CITY OF ALBUQUERQUE

**Re: Lot 2 Block 9 SAD 228
Volcano Cliffs Subdivision Unit 18
6605 Petirrojo Rd. NW
Grading and Drainage Plan
Engineers Stamp Date 11/2/2021 (D10D003I2)
Pad Certification Date 11/16/2021
CO Certification Date 12/13/2022**

Based on the Certification received 12/15/2022, the site cannot be accepted for release of Certificate of Occupancy by Hydrology until the following comments are addressed.

ENGINEER'S SEAL 	LOT 02 BLK 09 UN 18 VC 6605 PETIRROJO ROAD NW	DRAWN BY DEM DATE 2-27-21
	GRADING AND DRAINAGE PLAN	Lot 02 Blk 09 Un 18 VC.DWG
DAVID SOULE P.E. #14522	 Rio Grande Engineering PO BOX 93924 ALBUQUERQUE, NM 87199 (505) 321-9098	SHEET # C1
		JOB #

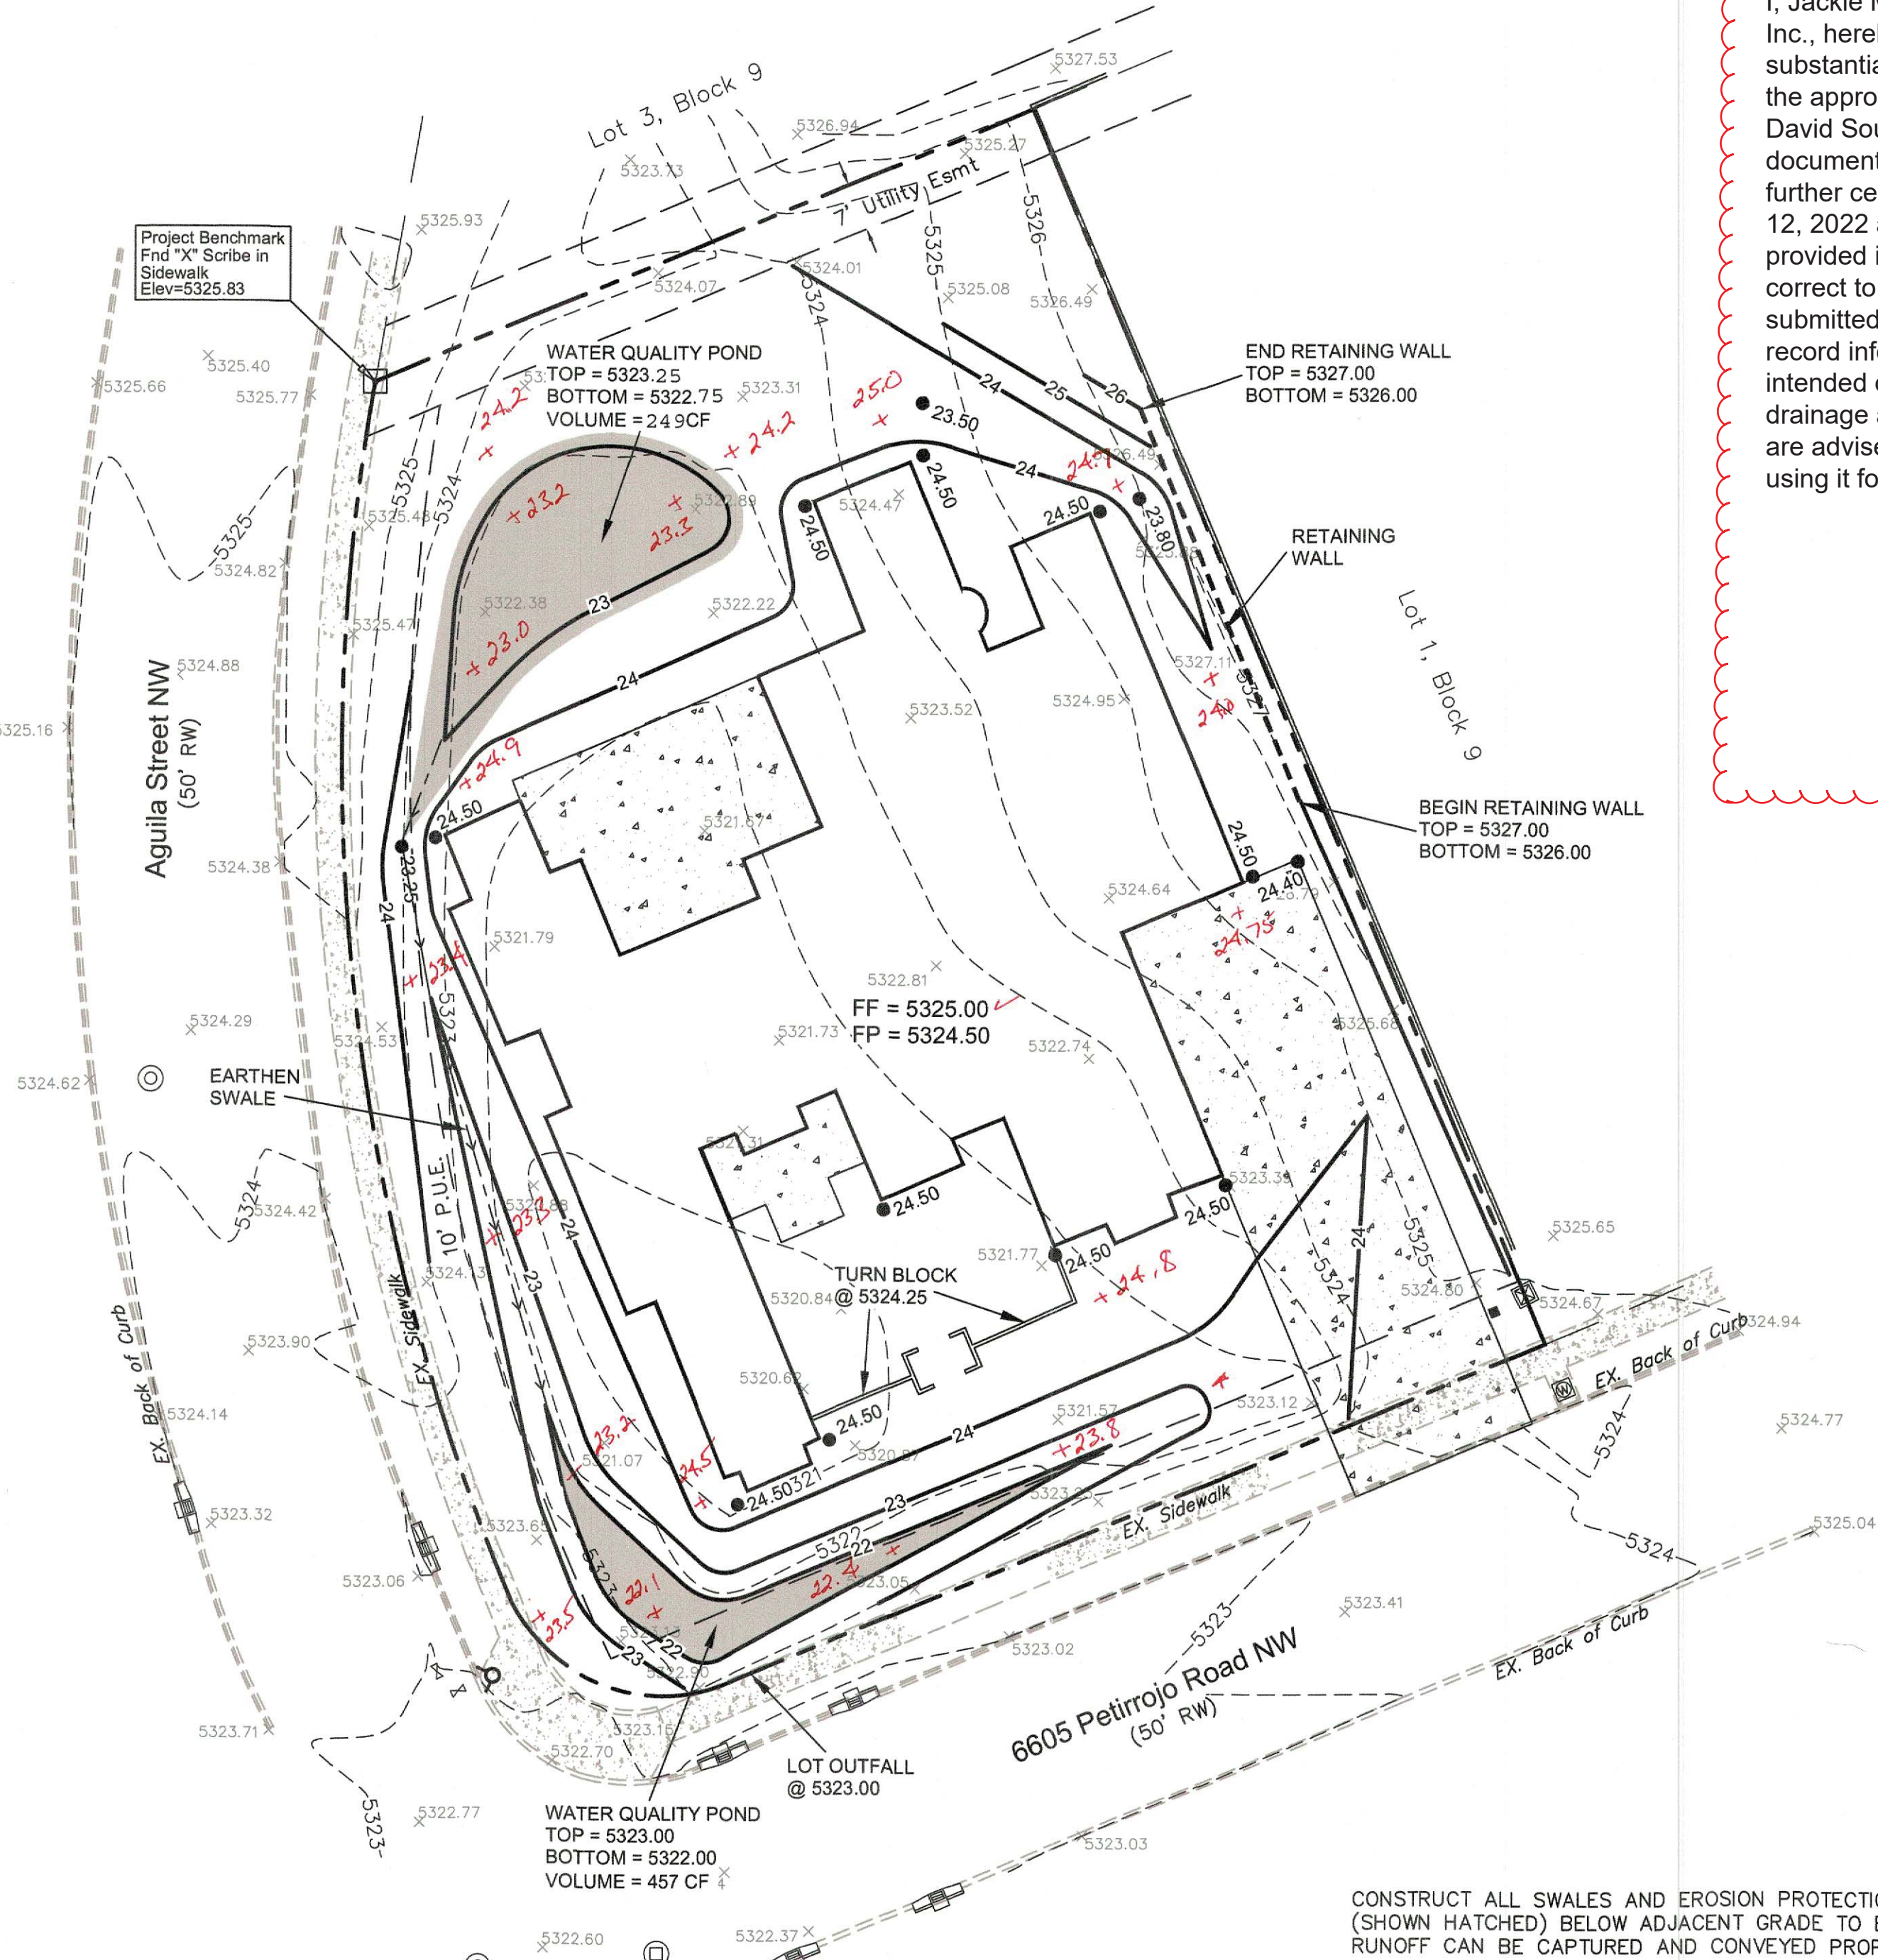
- Remove the port a potty.
- The back yard needs to have erosion protection.
- Replace the cracked side walk at the hand-I cap ramp.
- Replace the missing sidewalk in front of the drive pad,
